Harnett County
420 McKinney Pkwy

SUBJECT: SFD2102-0108
SINGLE FAMILY DWELLING

Here are the results of all Inspections located at **364 WINDY FARM DR:**

**GARAGE WING WALL** 3/8" = 1'-0" **9**

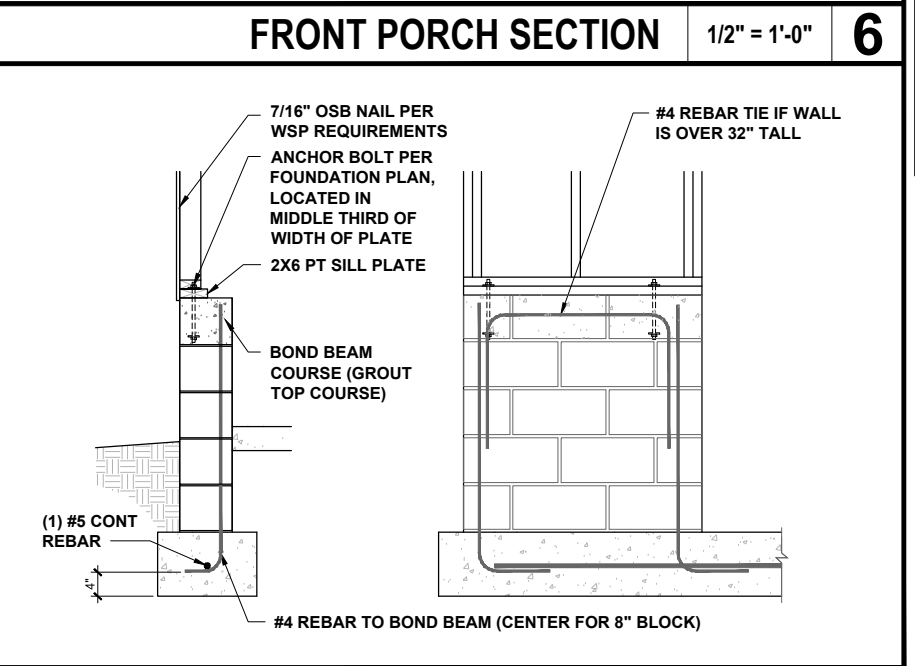
Missing 2" square washers at garage wing walls. Also plumbing drain test not up.

3rd party letters on garage wall and rear window stud in attachments. Repair approved.

METHOD PF: PORTAL FRAME PANEL CONSTRUCTION 3/8" = 1'-0" 1

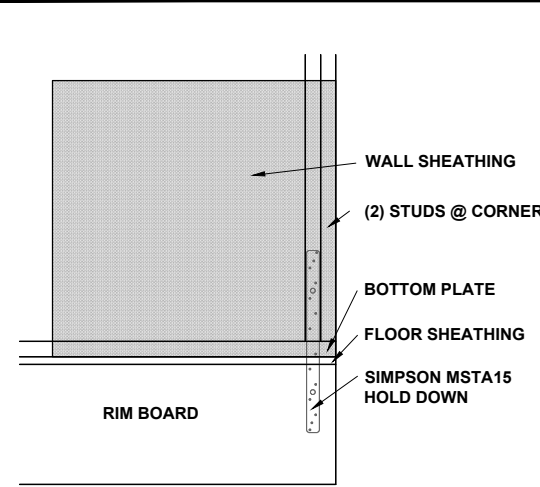
1. Rear window at family room header not continuous/framed as shown on plan. 2. Front and rear porch beams covered before inspection. 3. Anchors at portal frame incorrect. Drilled in anchors were used instead of embedded anchors. Provide engineers letter. 4. Draft stop upstairs tub drain. 5. No water on plumbing drain test. 6. Stud cut in exterior wall for range hood vent. 7. Uncover rear porch footings for inspection of post to footing.
